Wall reconstruction, 145 Cumberland Ave

Christina Stacey <cstacey@portlandmaine.gov>
To: chris@gnomelandscapes.com

Wed, Feb 15, 2017 at 8:28 AM

PROJECT: **CUMBERLAND AVE., MSE PORTLAND, MAINE**
 SHEET TITLE: **KEYSTONE WALL ELEVATION & PARTIAL SITE PLAN**

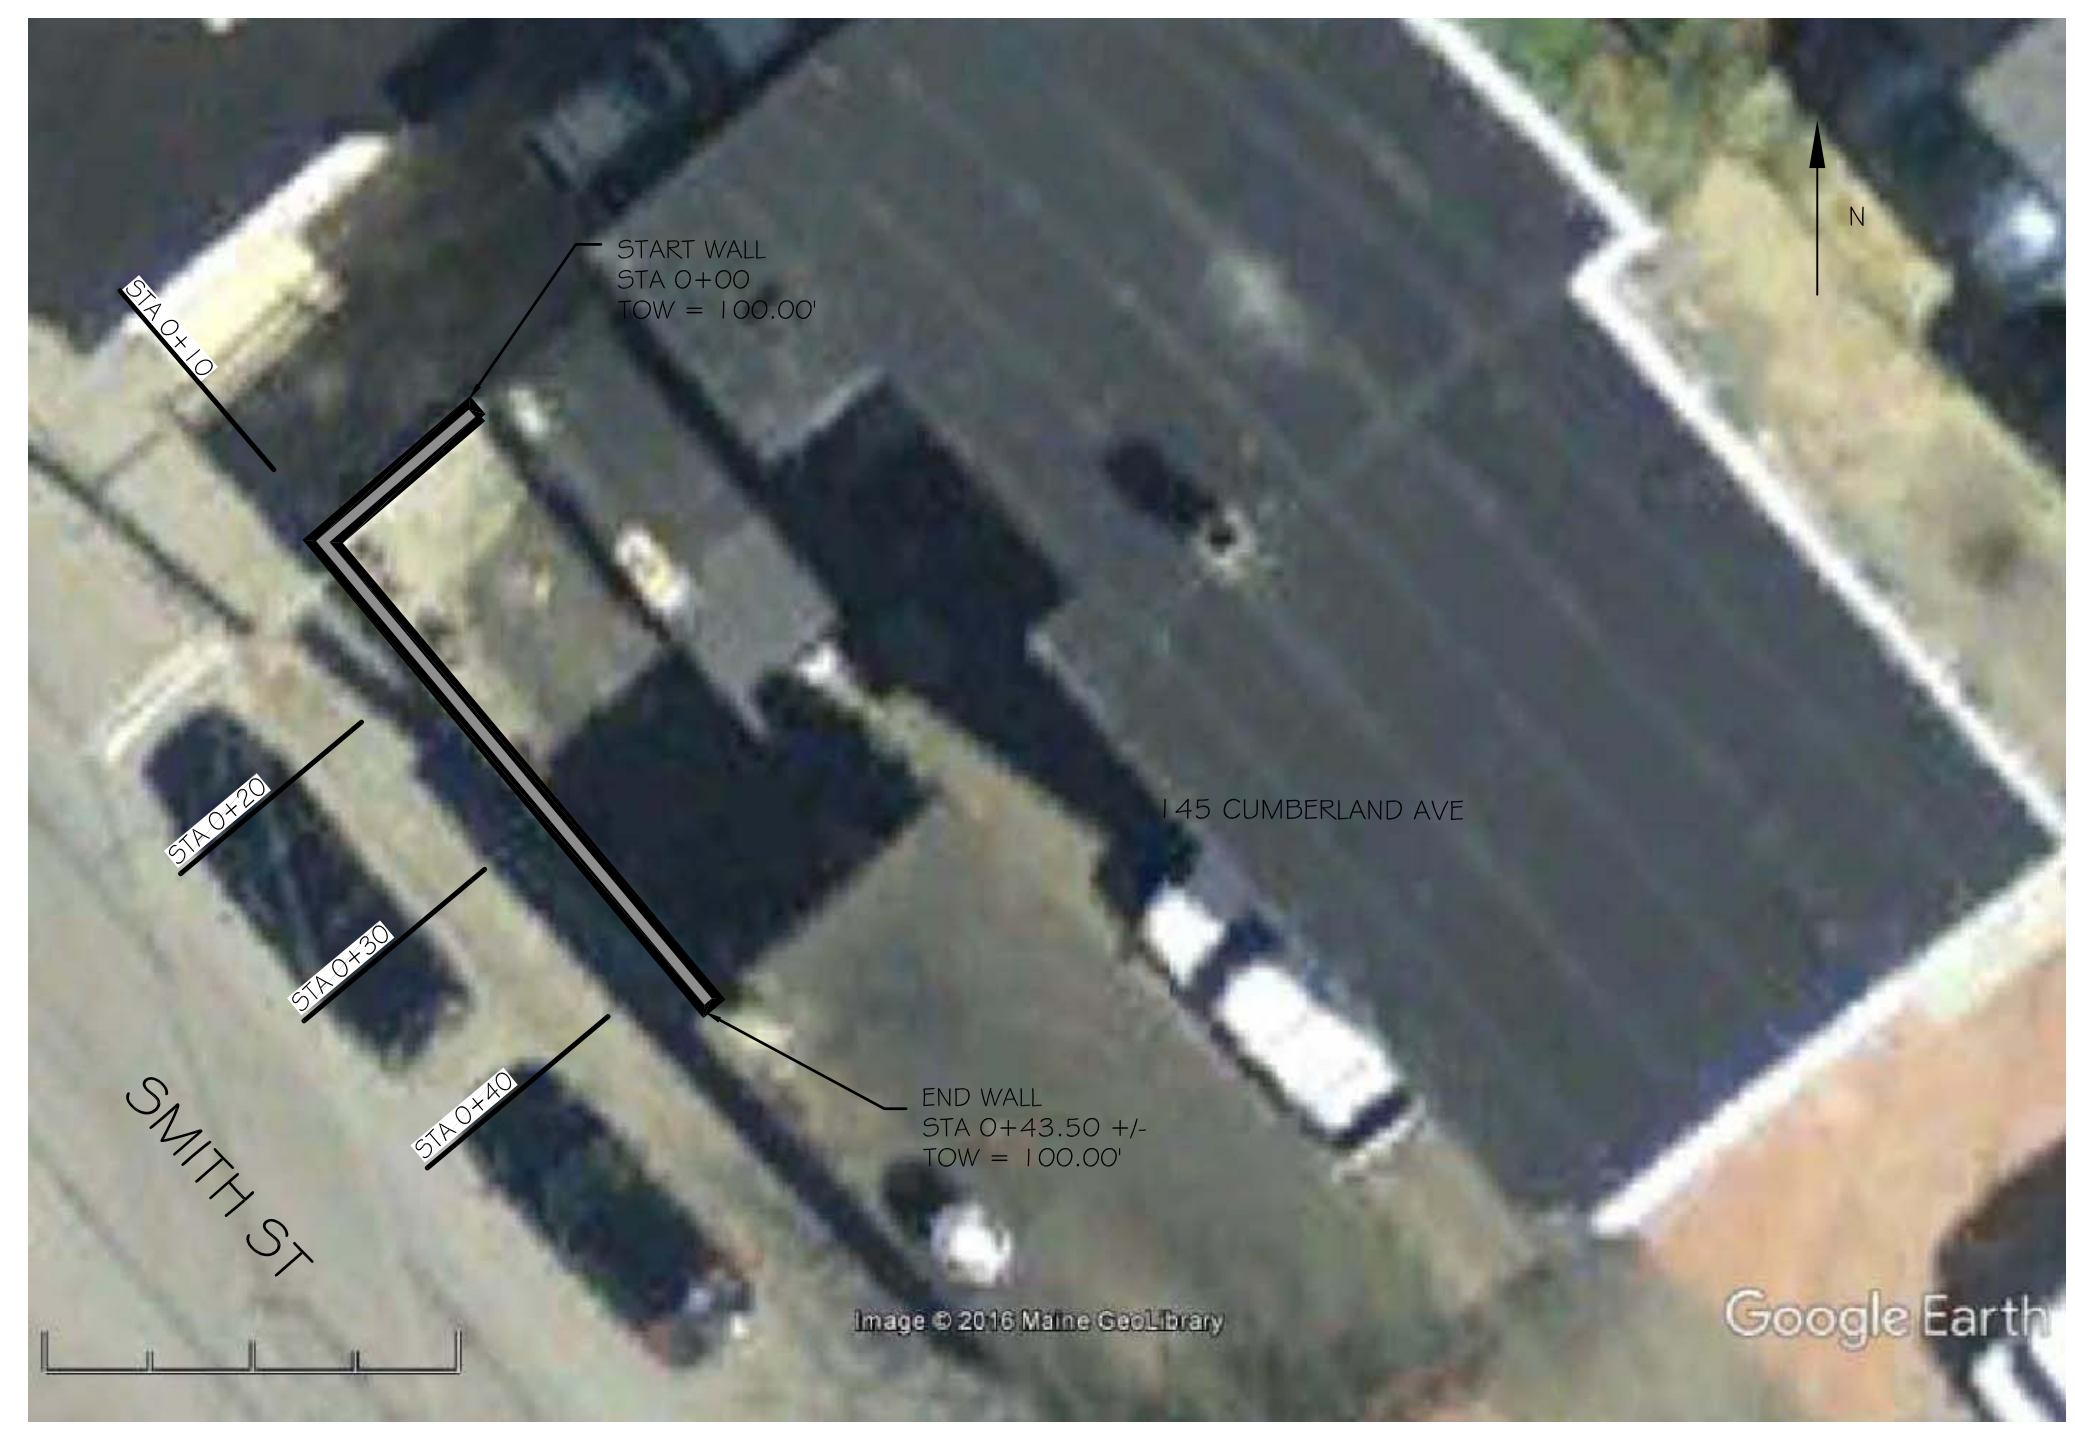
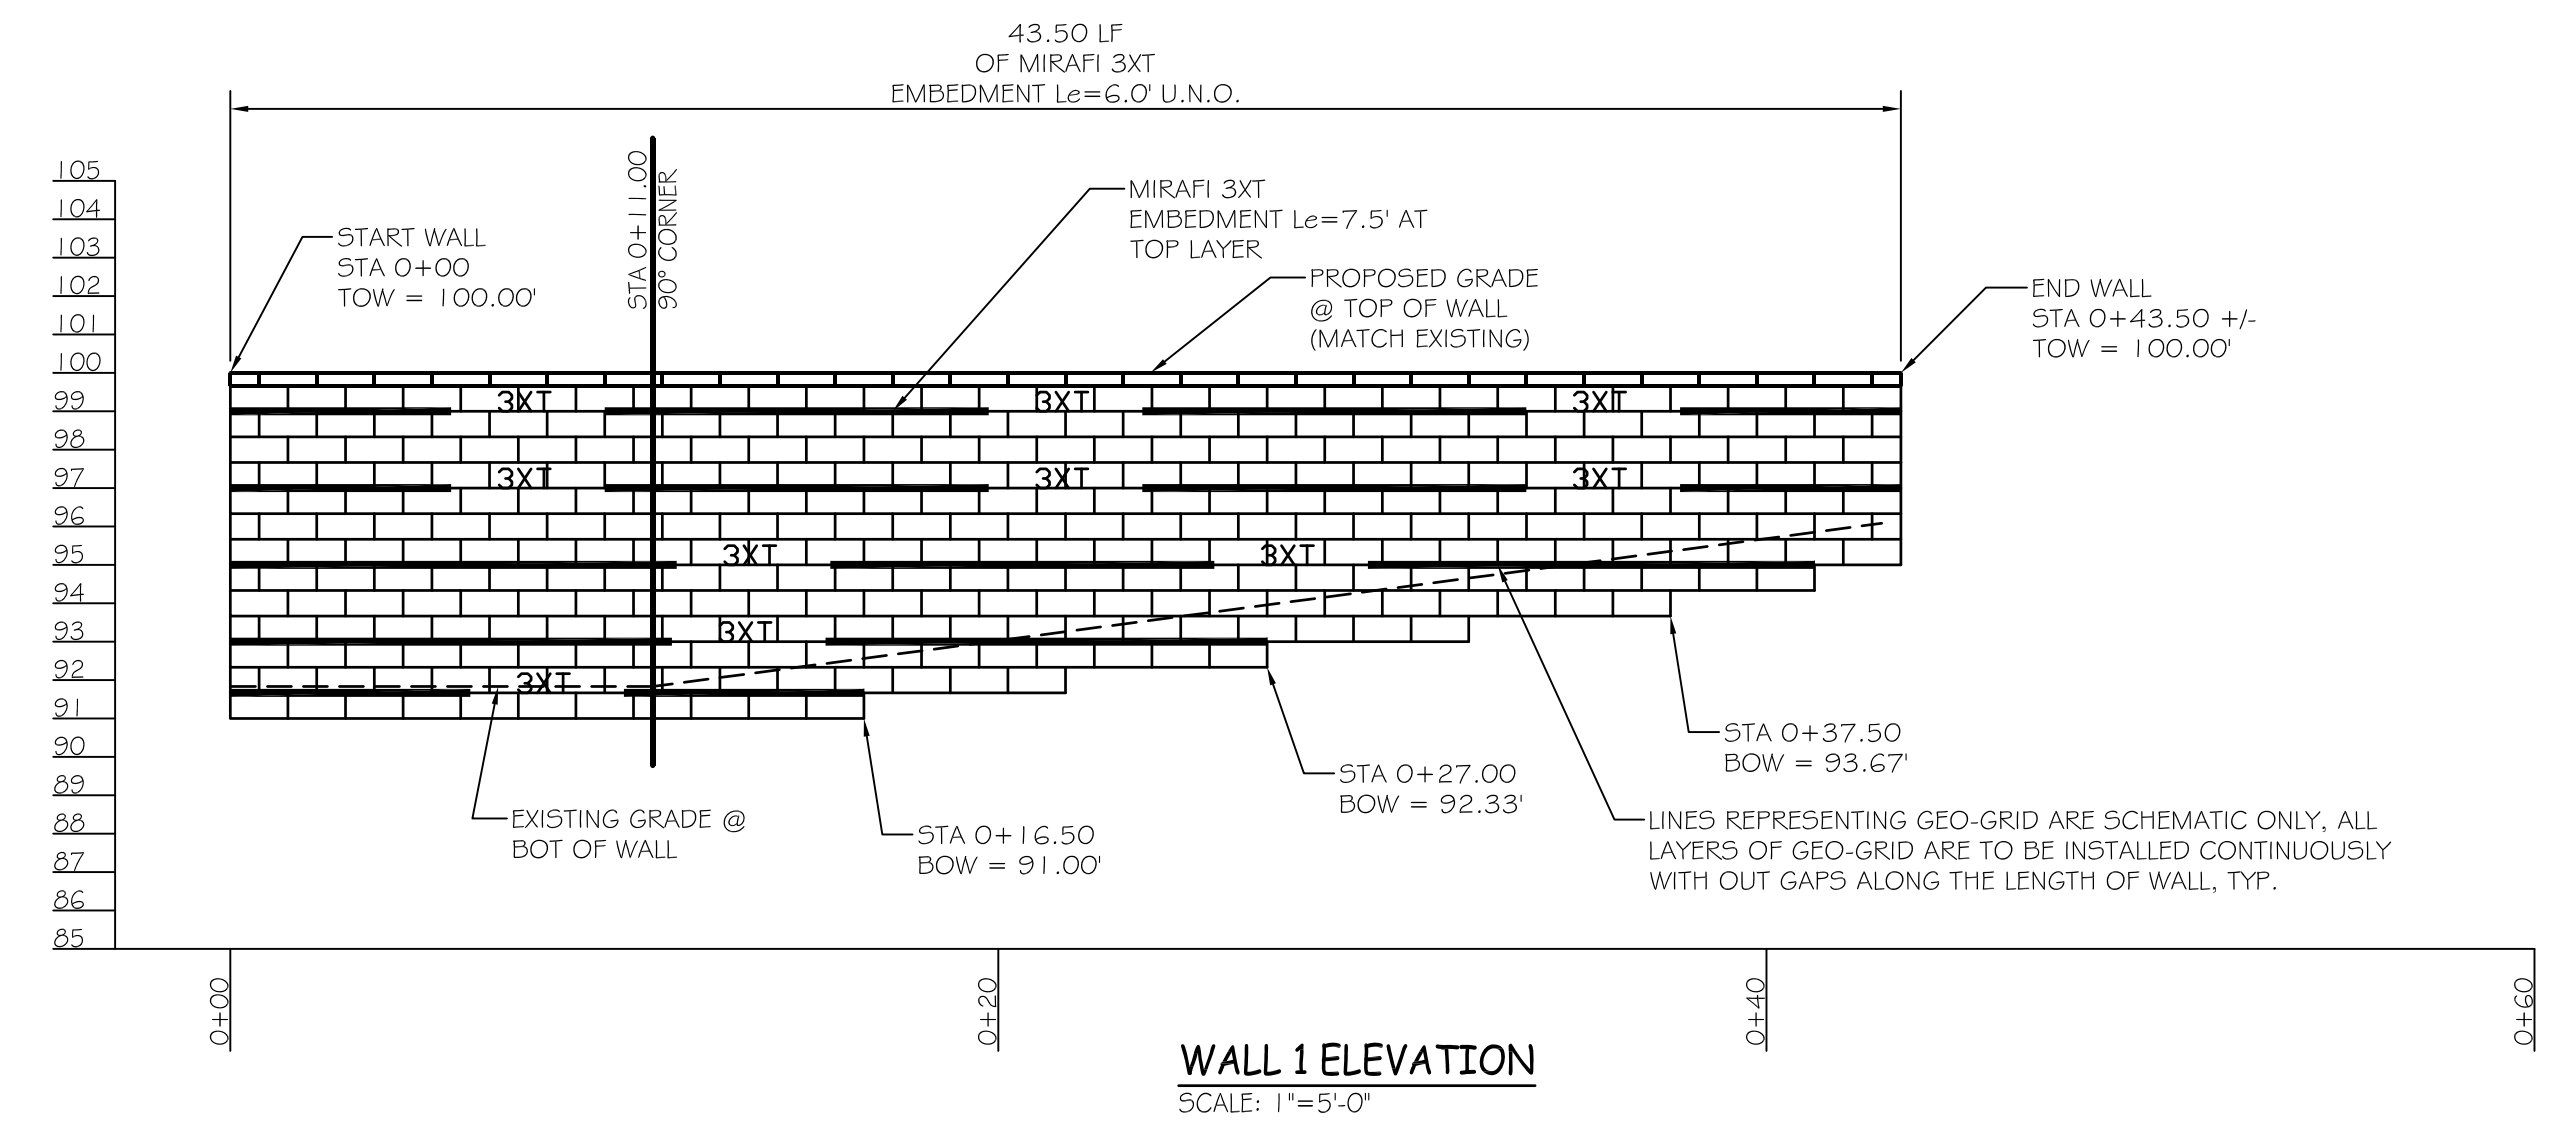
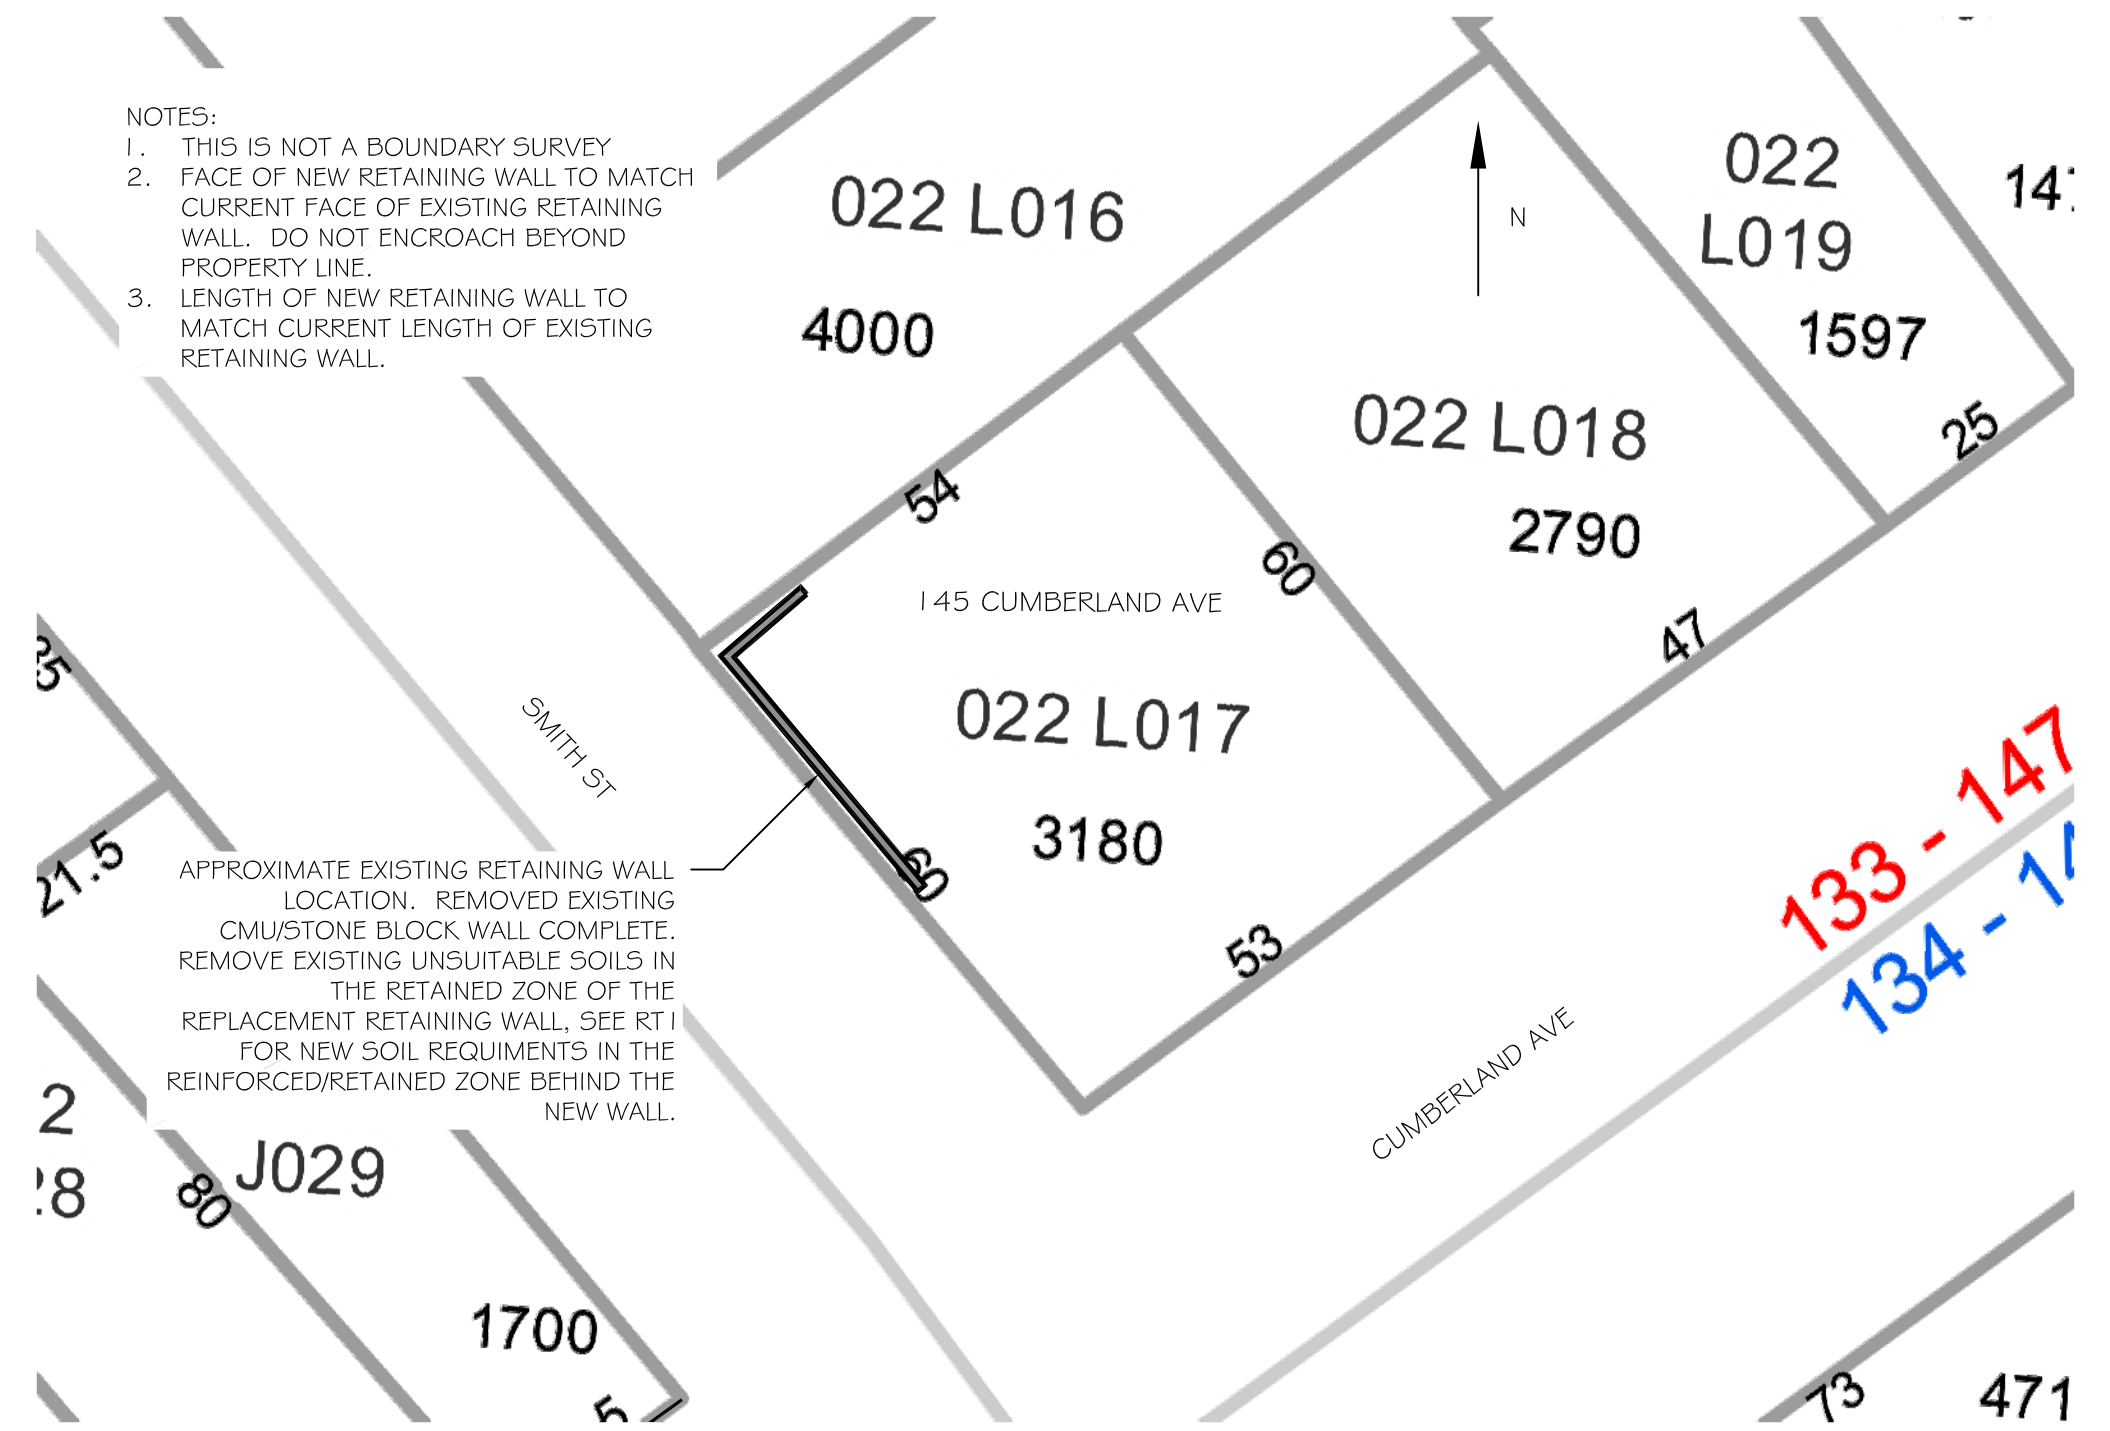
2) There is a bit of a discrepancy with regards to the property line. The boundary survey from Owen Haskell appears to show the existing wall encroaching a small amount into the City right-of-way, but the engineered plan implies that the current face of the wall is completely within the property boundaries. If necessary, can the reconstructed wall be slightly adjusted to ensure it's entirely on the private property?

AML owns the building as well as the bagel shop. Does that eliminate the need for the letter? They are in agreement that that upper corner of the wall will be built behind the property line.

Let's build the wall to be clear of the city property and just be on our property
